Please ask for: Mrs D Johnson
Email: daun.johnson@arun.gov.uk
Telephone: 01903 737762
Our Ref: FG/41/20/PL
Your Ref:
Date: 9th April 2020

Application for Planning Permission

Development: 1 No new dwelling & detached hydrotherapy pool house along with associated external works & creation of 1 No additional vehicular entrance.
Location: Ferringham House 58 Ferringham Lane Ferring BN12 5LU

Proposed Block Plan - 1:500 @ A1

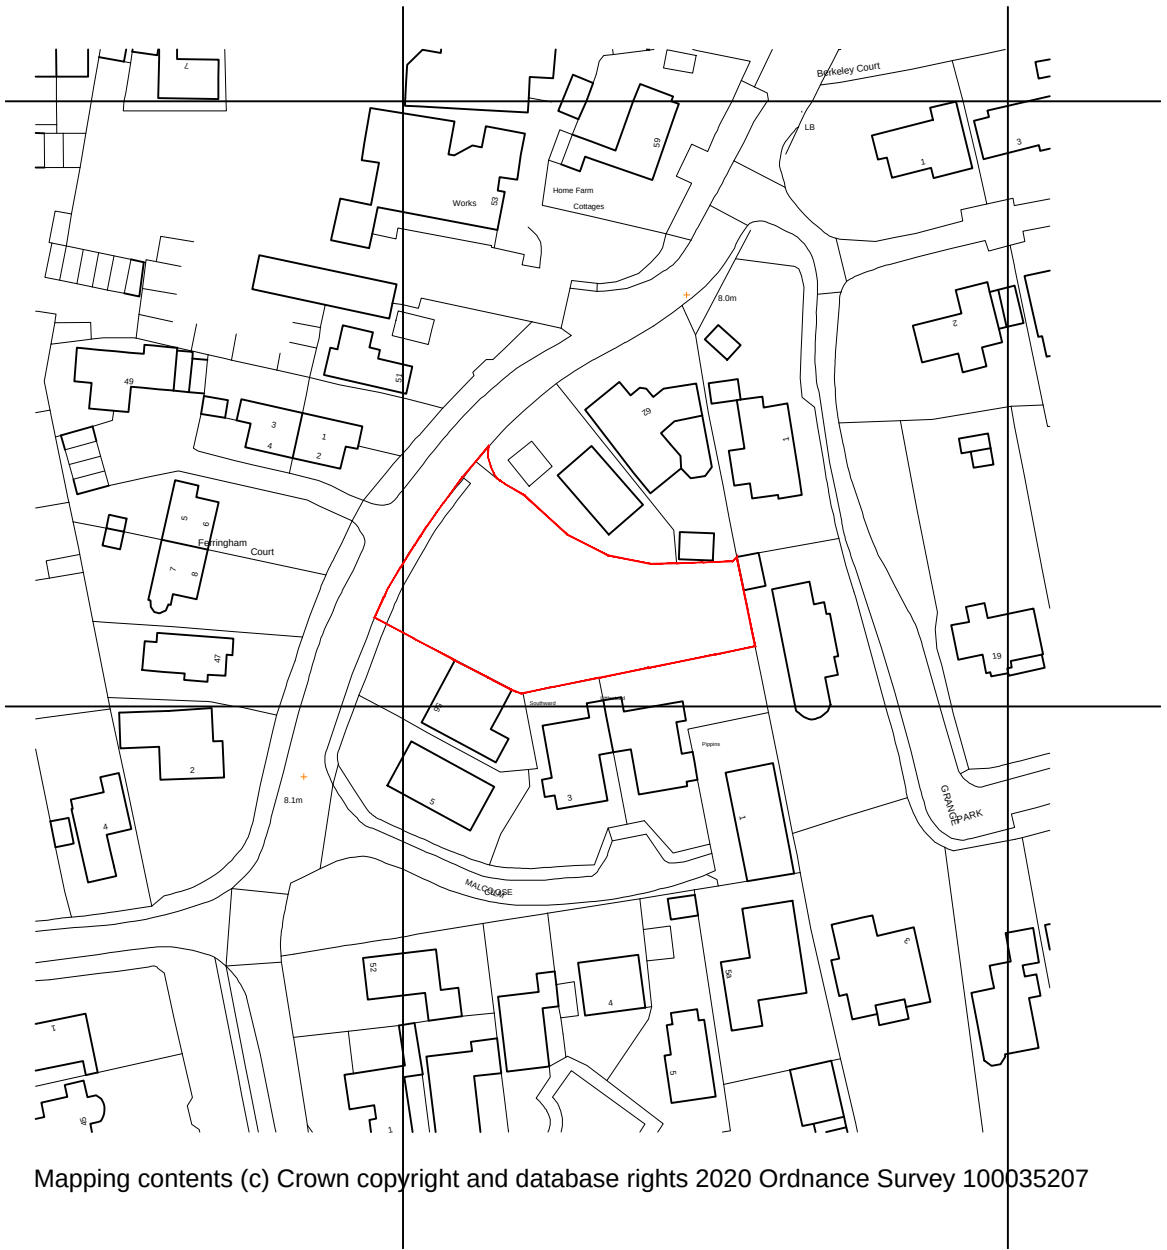
Block Plan

Please show the proposed access and provide measurements from the proposals to the site boundaries.
